Application for a non-material amendment following a grant of planning permission.

Number	1
Suffix	
Property name	
Address line 1	Rose Mount
Address line 2	Birkby
Address line 3	
Town/city	Huddersfield
Postcode	HD2 2BU

ERECTION OF SINGLE STOREY EXTENSION	
Reference number:	2020/62/90417/W
Date of decision	04/05/2020
What was the original application type?	Householder Planning Permission

Proposed Ground Floor & Site Plan

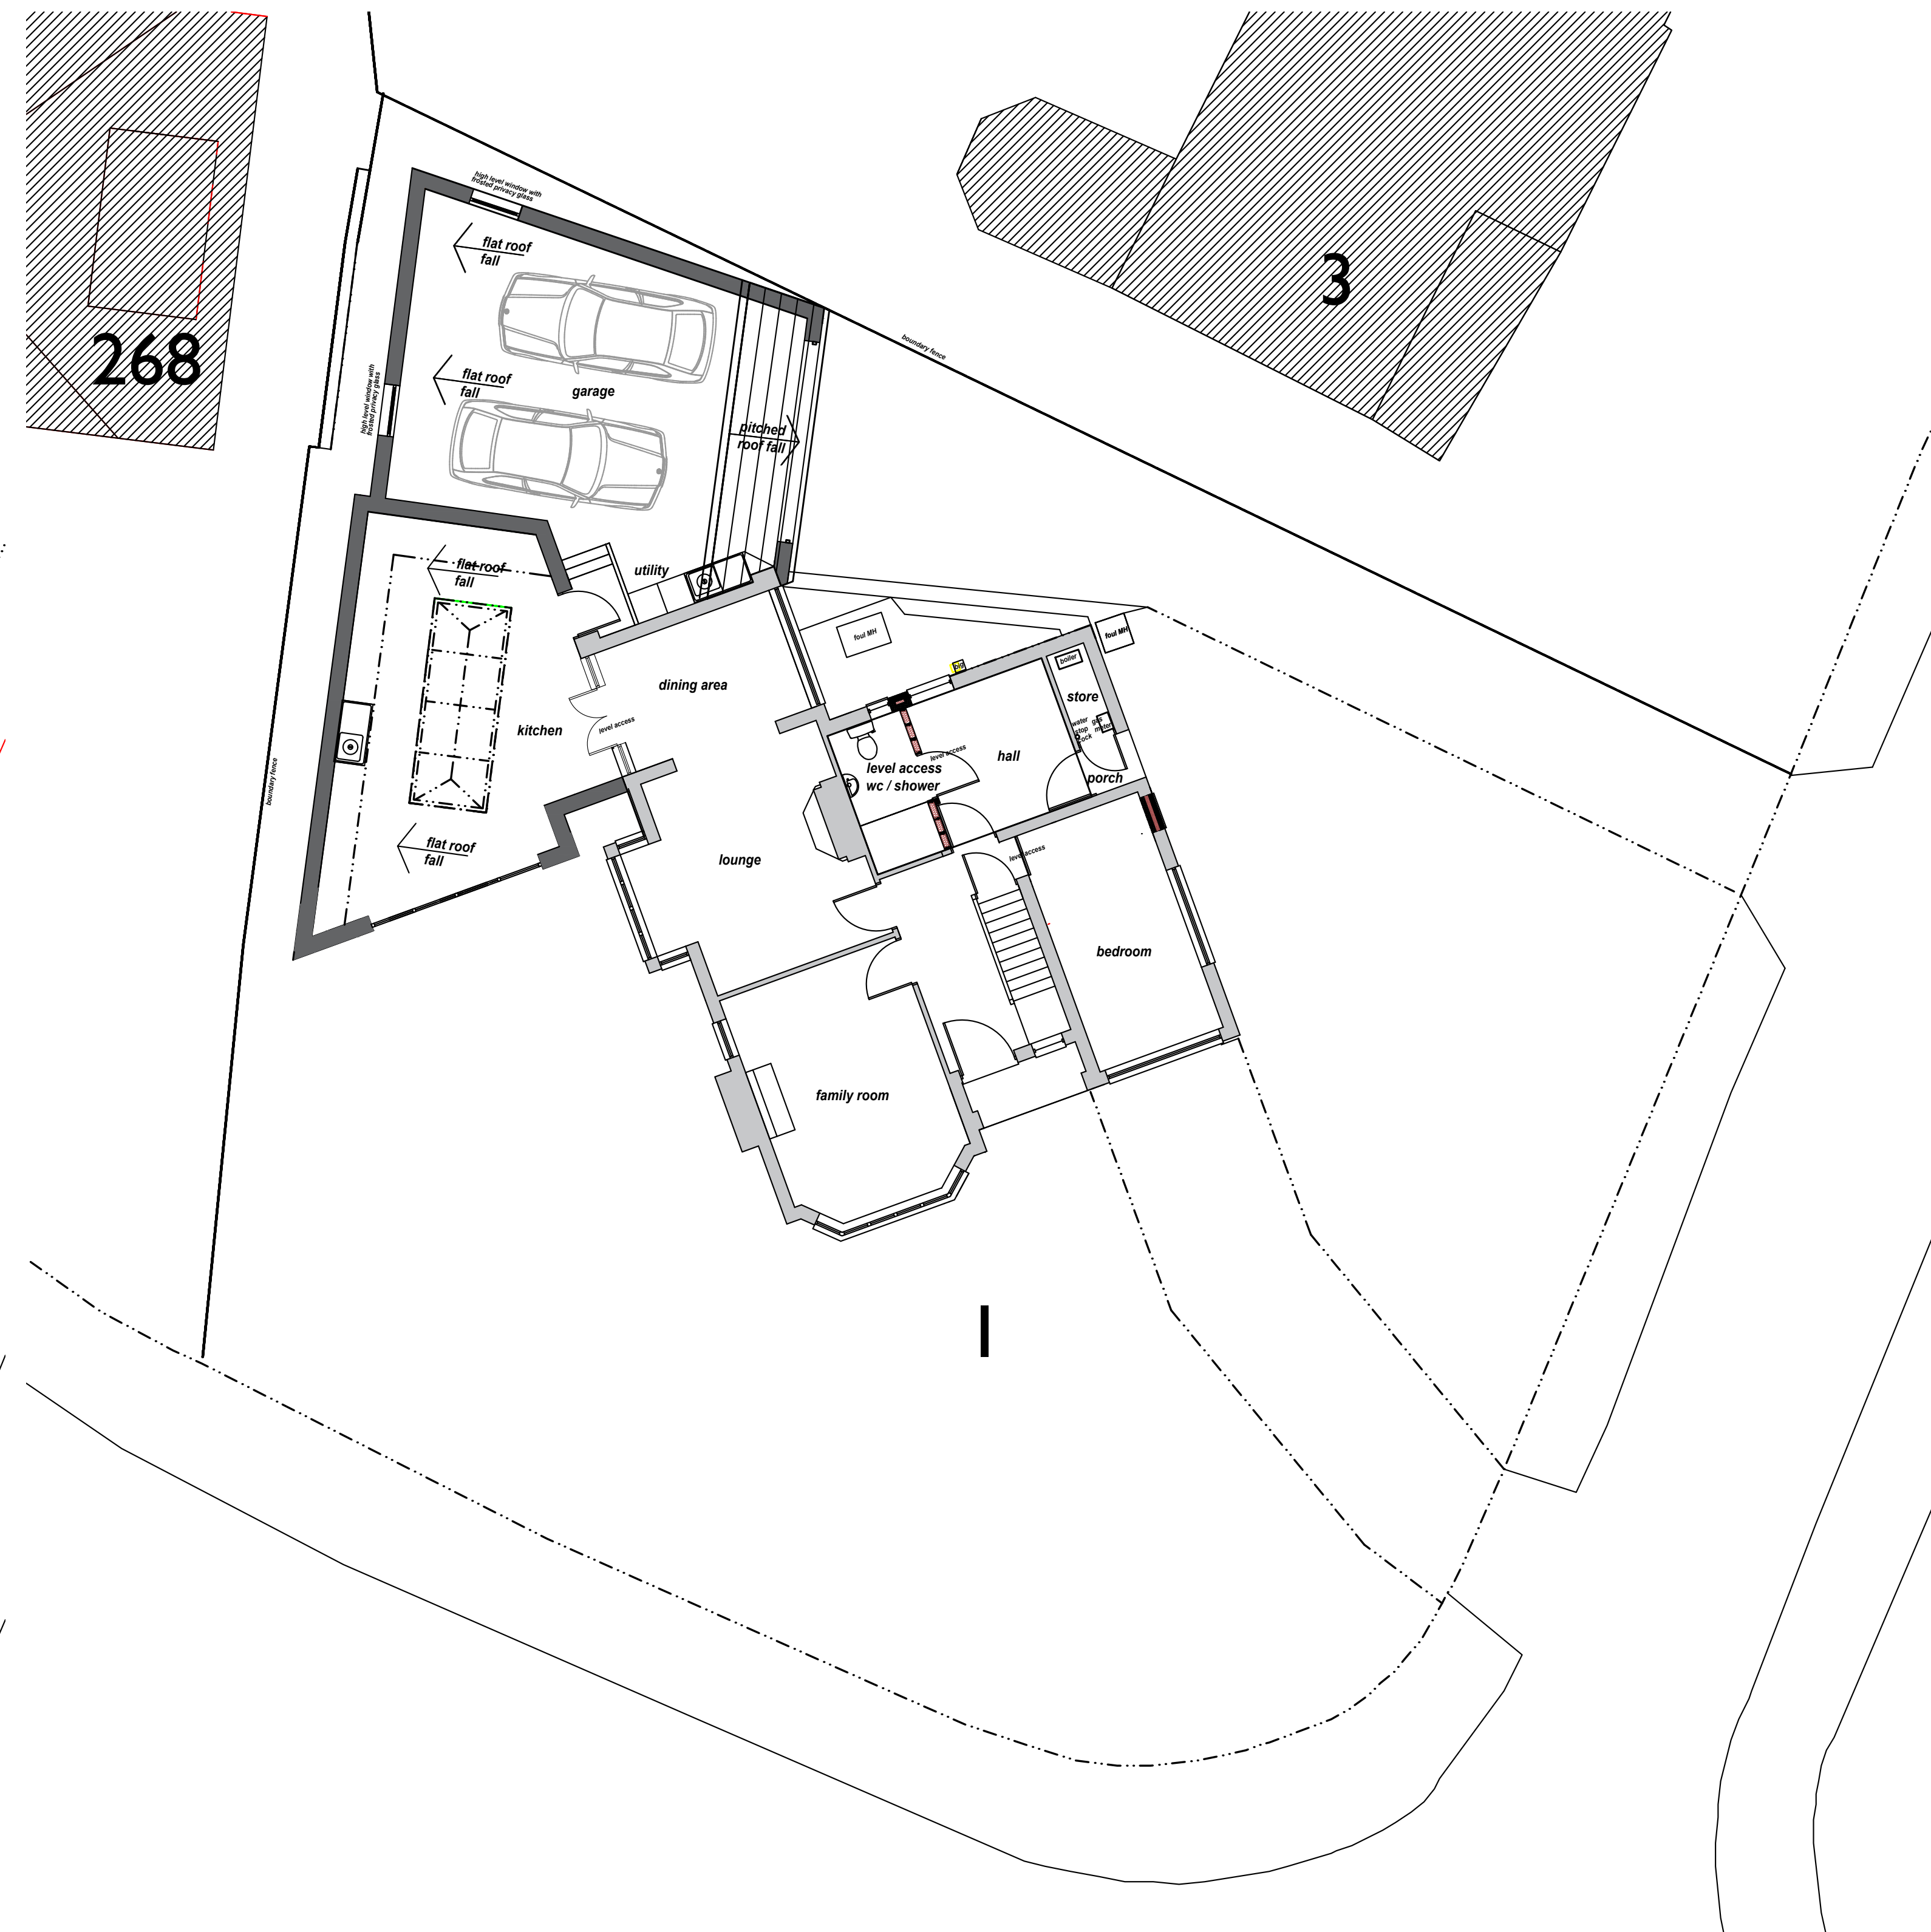
kitchen window/rooflight resized, set-back in kitchen/garage rear wall, tiled roof section over garage door
Are you intending to substitute amended plans or drawings? ☒ Yes ☐ No
If yes please complete the following
Old plan/drawing numbers
1. Existing and proposed site plan and floor plan
2. Existing and proposed elevations
New plan/drawing numbers
1. Existing and proposed site plan and floor plan_Rev01
2. Existing and proposed elevations_Rev01
Please state why you wish to make this amendment
Due to technical issues & in the interests of good neighbourliness we wish to seek approval of minor revisions to existing approval 2020/90417 to allow work to start next month:

- a) longer kitchen window/rooflight for better natural daylight distribution to kitchen
- b) small set-back to kitchen/garage rear wall allows structural expansion joint & dimensional coordination of kitchen units
- c) use of tiled roof section over garage frontage helps to tie this in aesthetically with house
